Re: Screening application 21/01374/SO and outline application 21/01224/OUT for development of land at former RAF Bicester, now Bicester Motion, Bicester OX26 5HA

CPRE **objects** to both the LPA's screening decision not requesting an EIA and to the outline application to construct an 'automotive experience quarter' on the Bicester airfield for the reasons outlined below:

Response to outline application 21/01224/OUT.

Figure 2.3.1 Airfield, Tracks Layout and Features

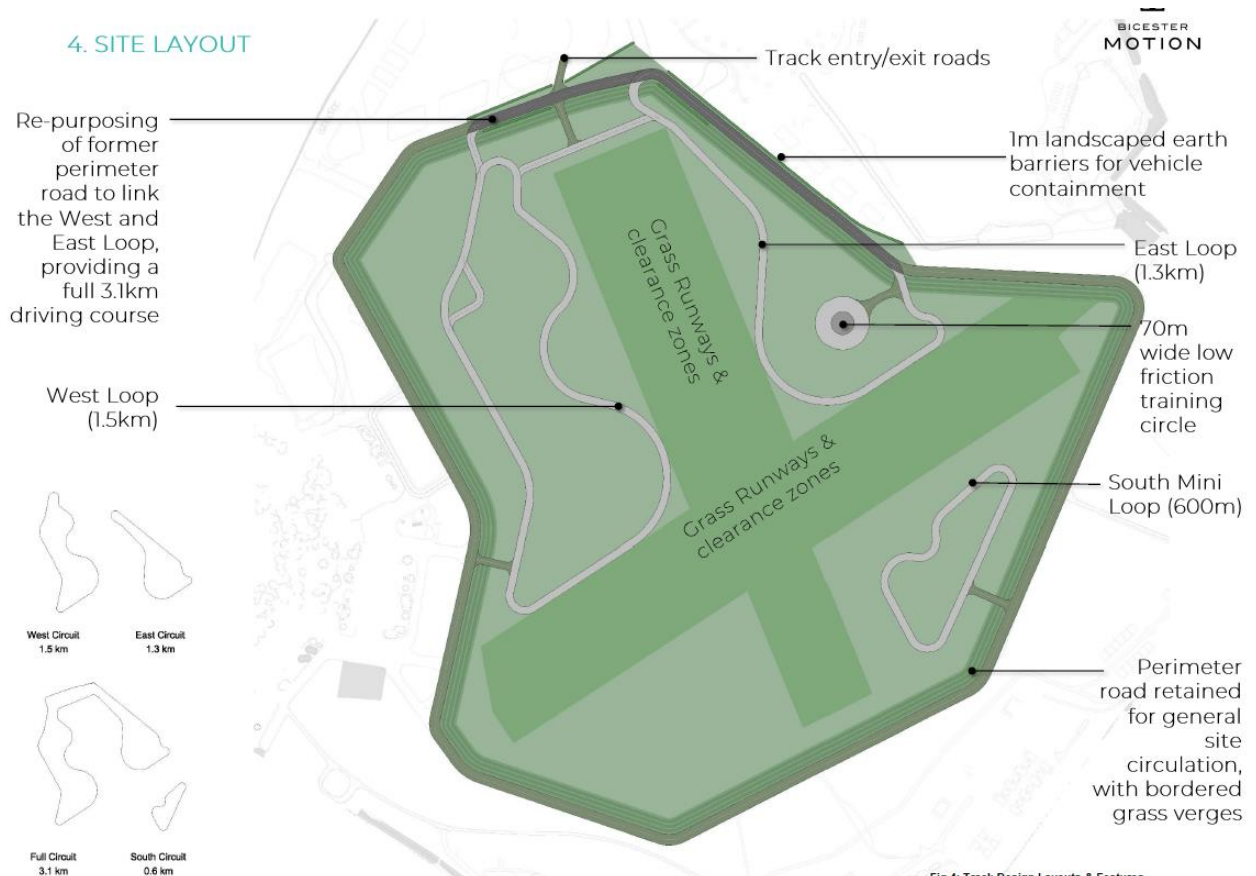
The applicant's plans mark the path of two fixed runways across the flying field.

Restricting take-off and landing of aircraft to these runways degrades the purpose of the "open flying field" which allows take-off in any wind direction and is recognised as such an important feature in Historic England's report on the site.

Figure 45. Proposed Automotive Demonstration And Driver Experience Diagram (not to scale)

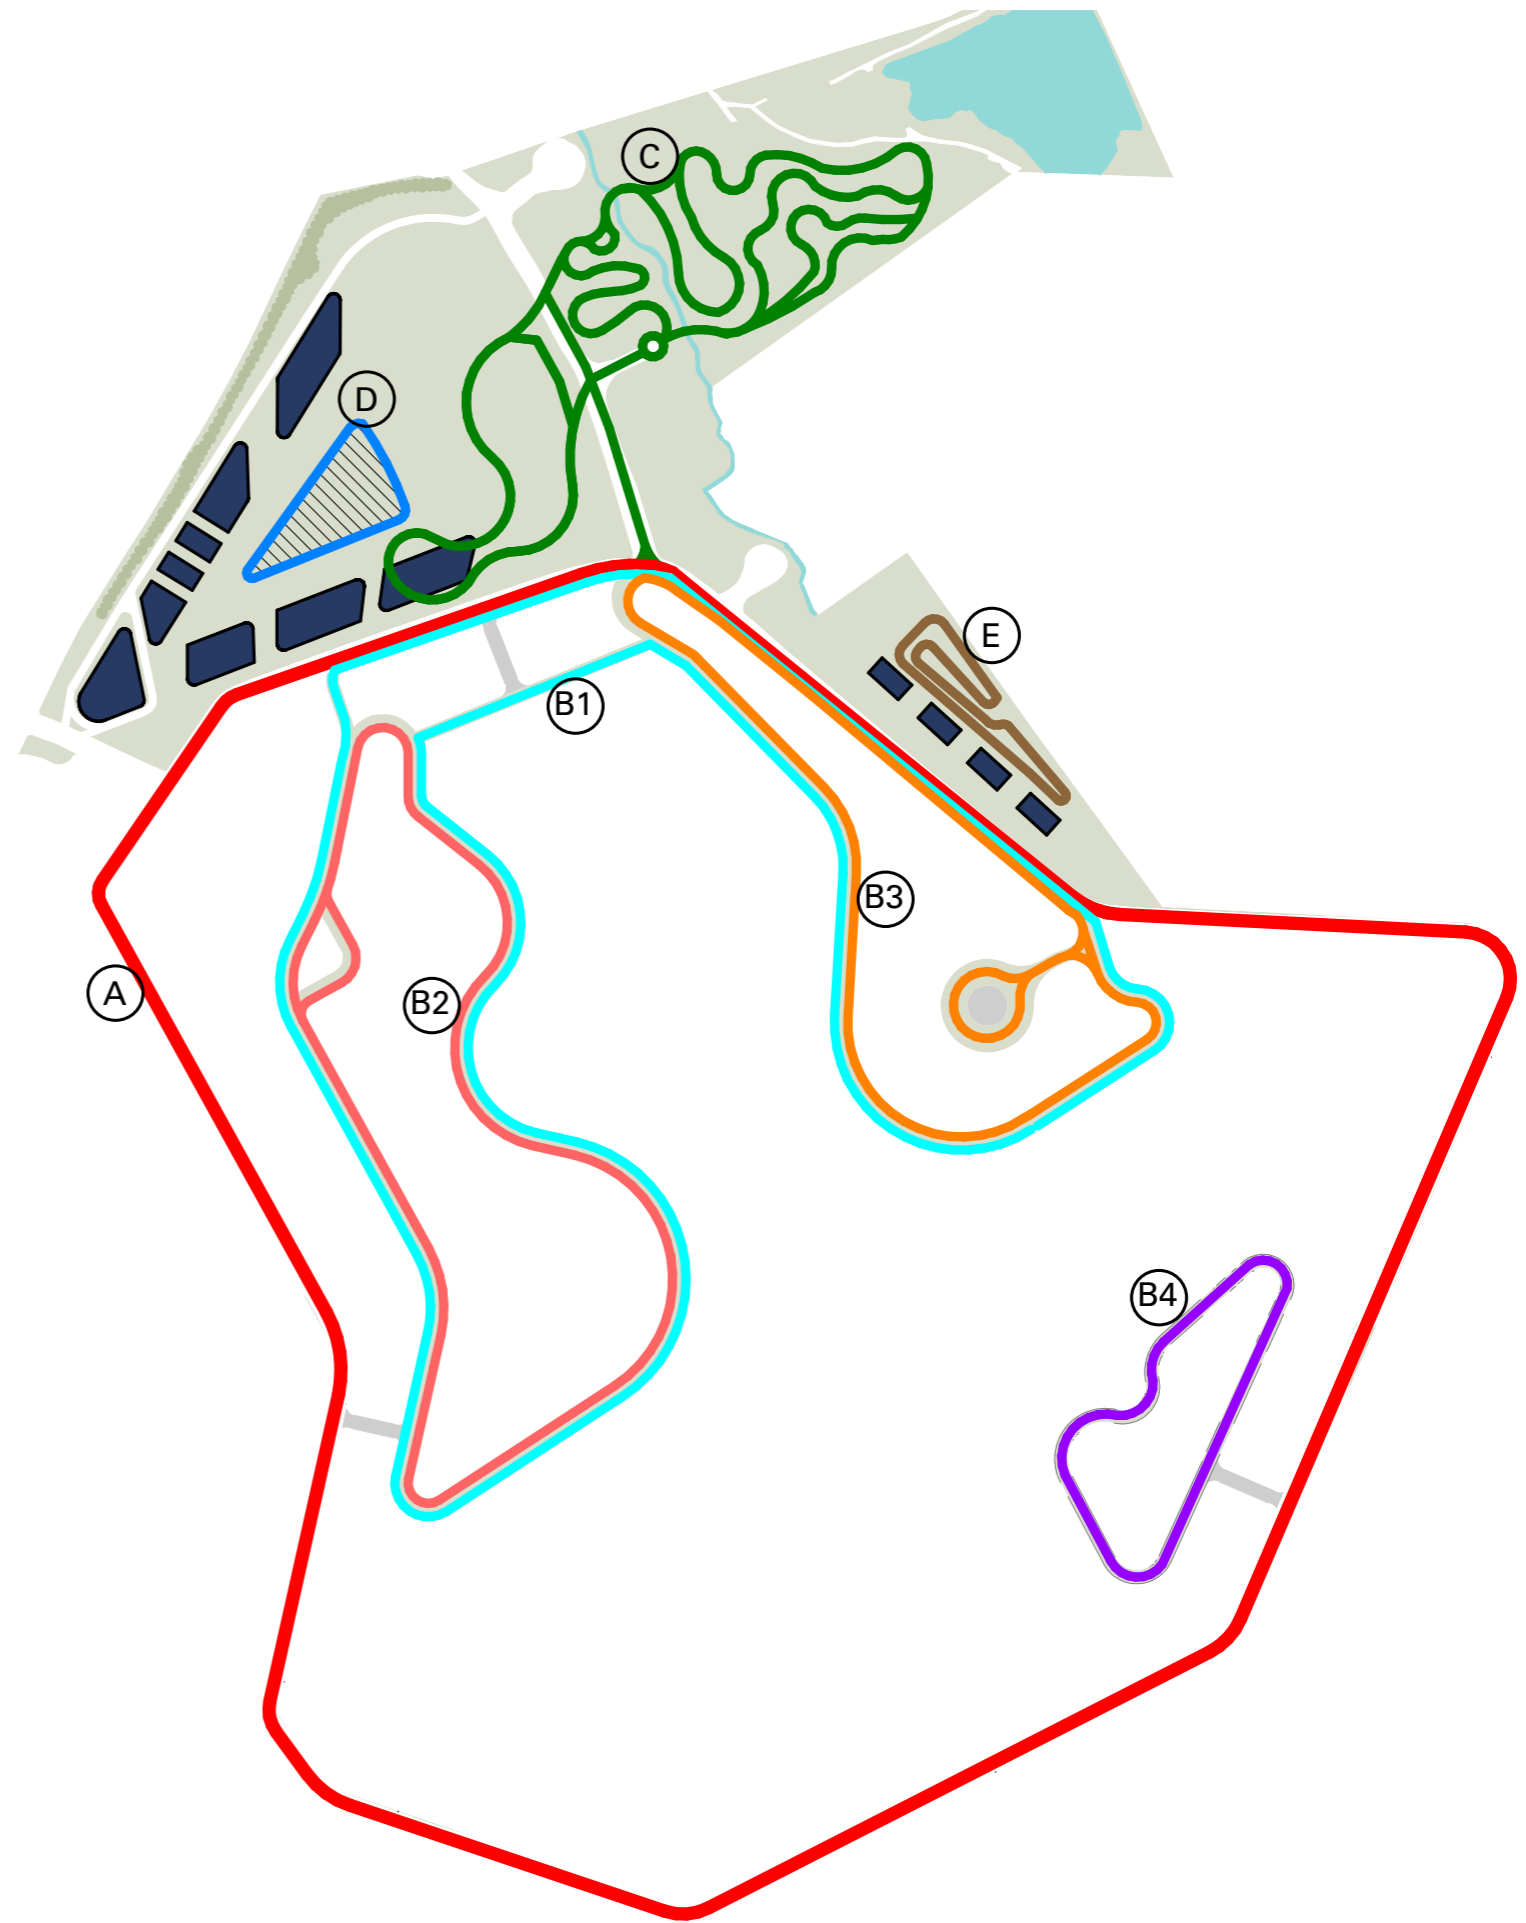
In addition, the proposals for a 4x4 track on the Stratton Audley Quarry (Elm Farm Quarry) are in contradiction to para C88 of the Local Plan which says that only low-intensity recreation use of the site is appropriate because it is a designated Local Wildlife Site (Site Code 62C01).
